**KIRKLEES METROPOLITAN COUNCIL
INVESTMENT & REGENERATION SERVICE**

DELEGATED DECISION TO DETERMINE PLANNING APPLICATIONS

| Reference No: | 2025/62/90648/W |
| Site Address: | 256, Reinwood Road, Quarmby, Huddersfield, HD3 4DS |

Site plan scale 1:100

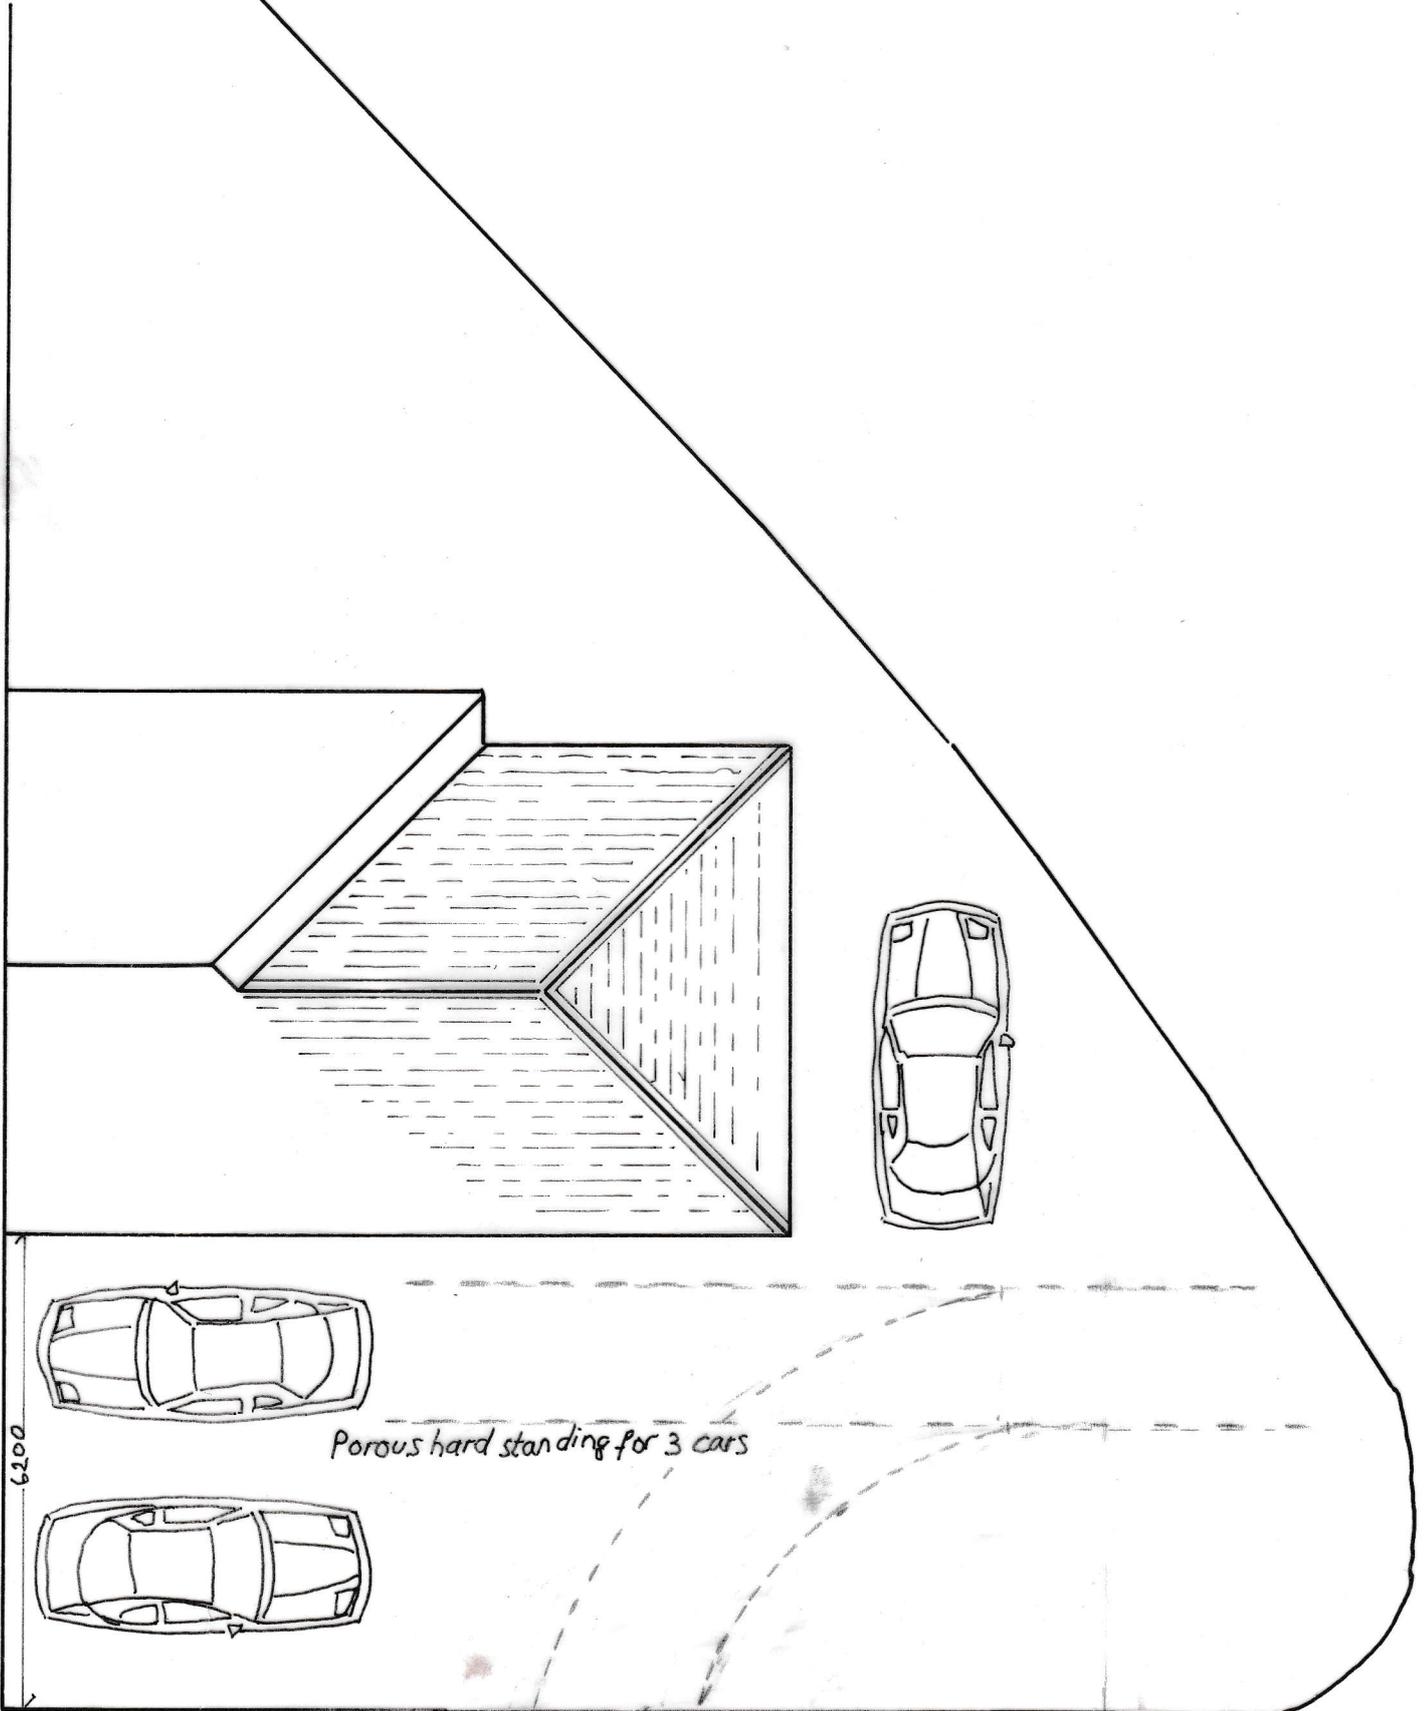
The submitted block plan demonstrates that the proposal would provide off-street parking for a minimum of three vehicles. To help mitigate potential flood risk, these parking spaces should be conditioned to be surfaced using a permeable surface material. The proposal does not propose any changes highway access, and it is therefore considered that the proposal is acceptable in relation to highway safety.

5. The development shall not be brought into use until all areas indicated to be used for parking on the submitted/listed plans have been laid out with a hardened and drained surface in accordance with the Communities and Local Government; and Environment Agency's 'Guidance on the permeable surfacing of front gardens (parking areas)' published 2009 as amended or any successor guidance. These areas shall be so retained, free of obstructions and available for the use specified on the submitted/listed plans for the lifetime of the development.
Reason: To ensure adequate space within the site for vehicle parking and to ensure adequate drainage of surface water within the site to mitigate flood risk in accordance with Policies LP22 and LP24 of the Kirklees Local Plan and advice within the National Planning Policy Framework.

Rear elevation scale 1:100

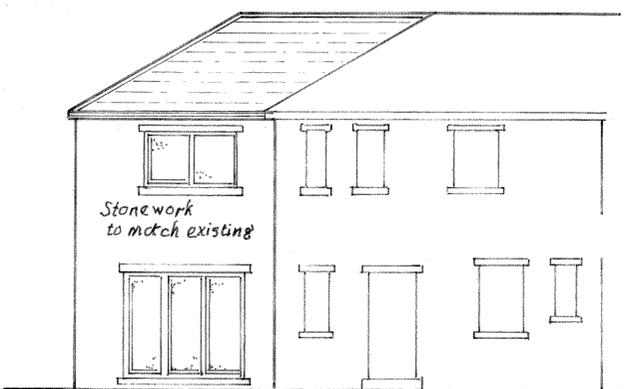
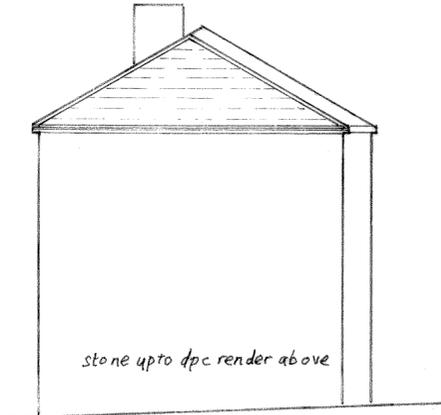
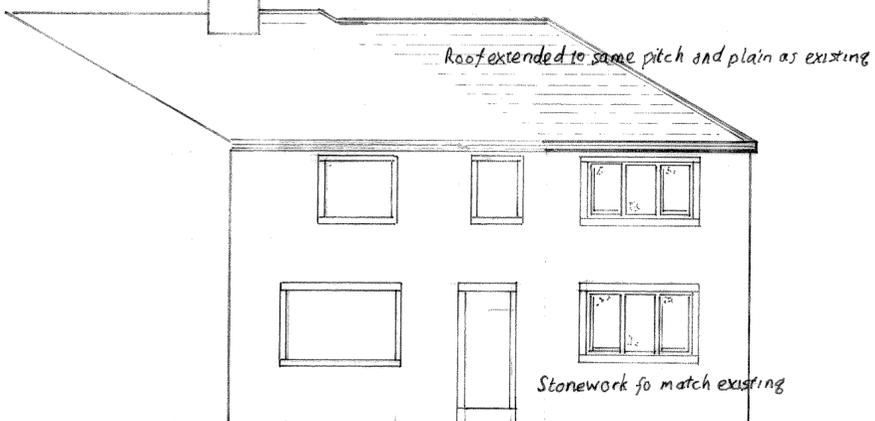
4. Notwithstanding the proposed rear elevation on the approved plans, the roof line shall be stepped down from the existing ridge height of the host dwelling as indicated on the proposed front and side elevations.
Reason: For the avoidance of doubt as to what is being permitted and so as to ensure the satisfactory appearance of the development on completion, and to accord with Policies LP01, LP02 & LP24, of the Kirklees Local Plan and advice in the National Planning Policy Framework.
